CITY OF ALBUQUERQUE

May 10, 2024

Re: Bartlett Offices
7441 Bartlett St. NE
30-Day Temporary Certificate of Occupancy
Transportation Development Final Inspection
Architect's Stamp dated 11-22-22 (D17-D113)
Certification dated 05-03-24

PROJECT TITLE 7441 BARTLETT	DATE 11/22/22	SHEET AS101
7441 BARLETT ST NE, ALBUQUERQUE NM 87109	JOB NO. XXX	
PROJECT MANAGER JPF	DRAWN BY: XXX	
SHEET TITLE SITE PLAN

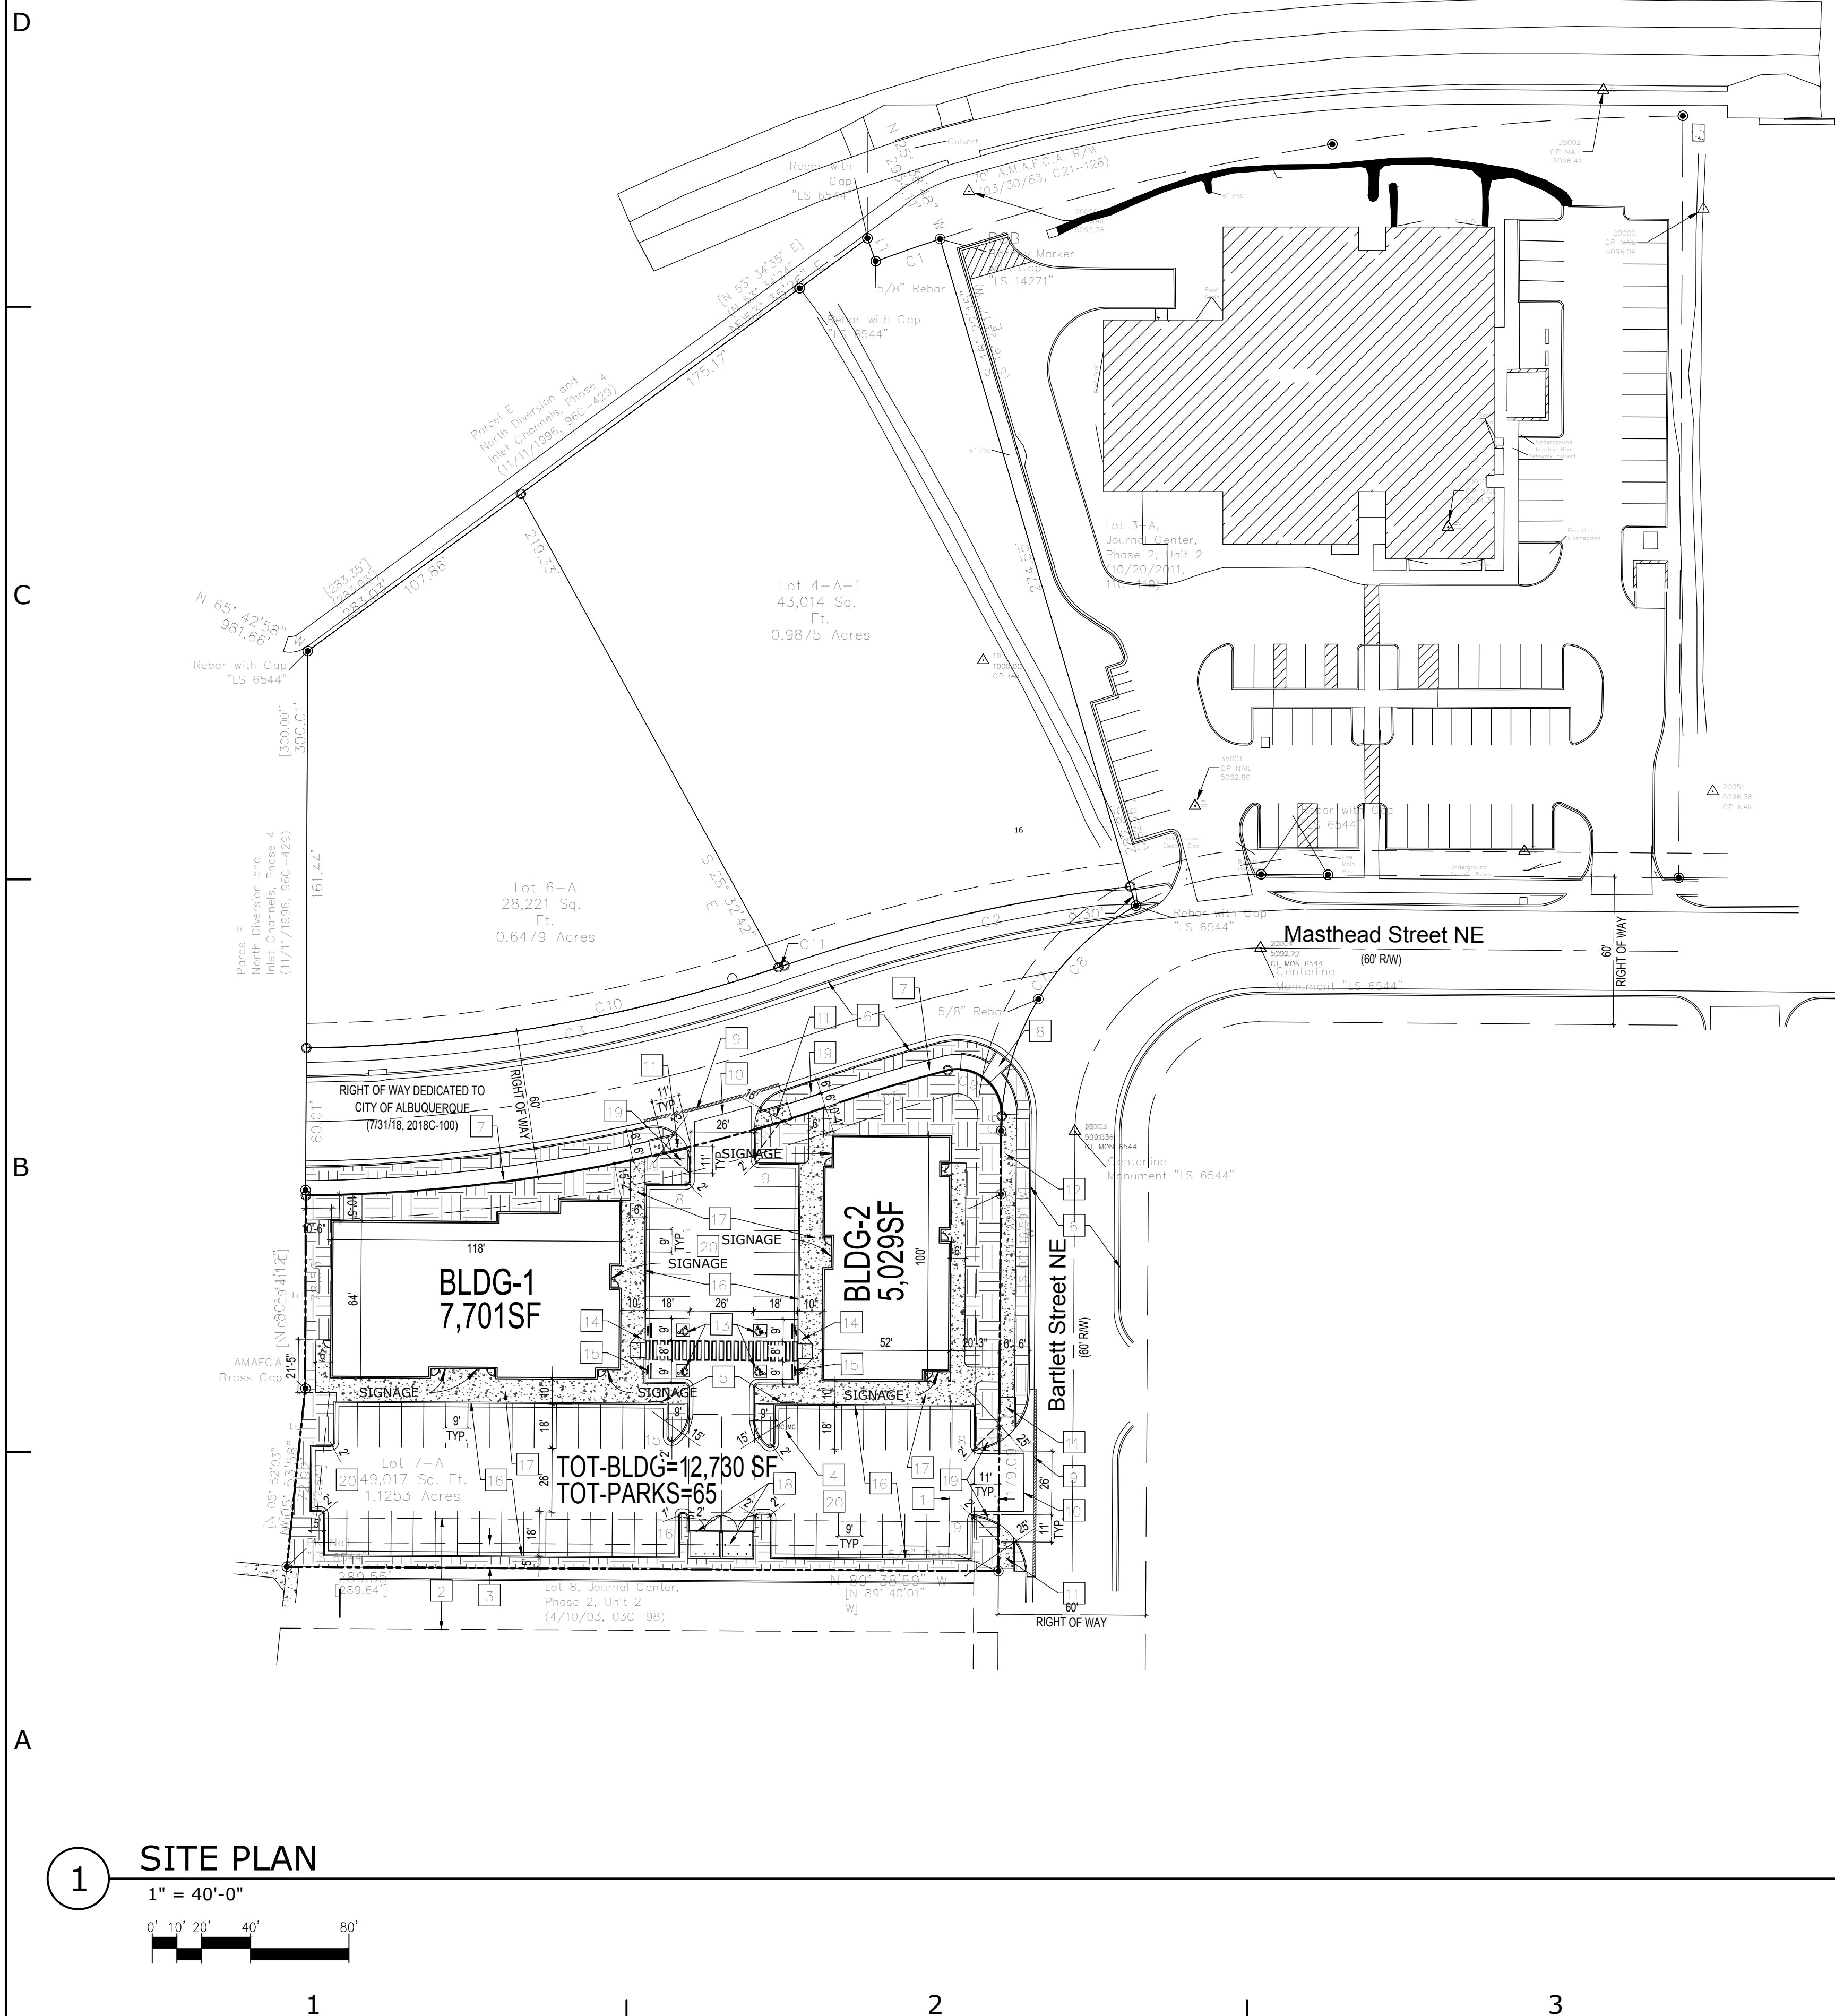
1. Per the approved site plan and the details sheet, please install bike rack that meets city's standard.
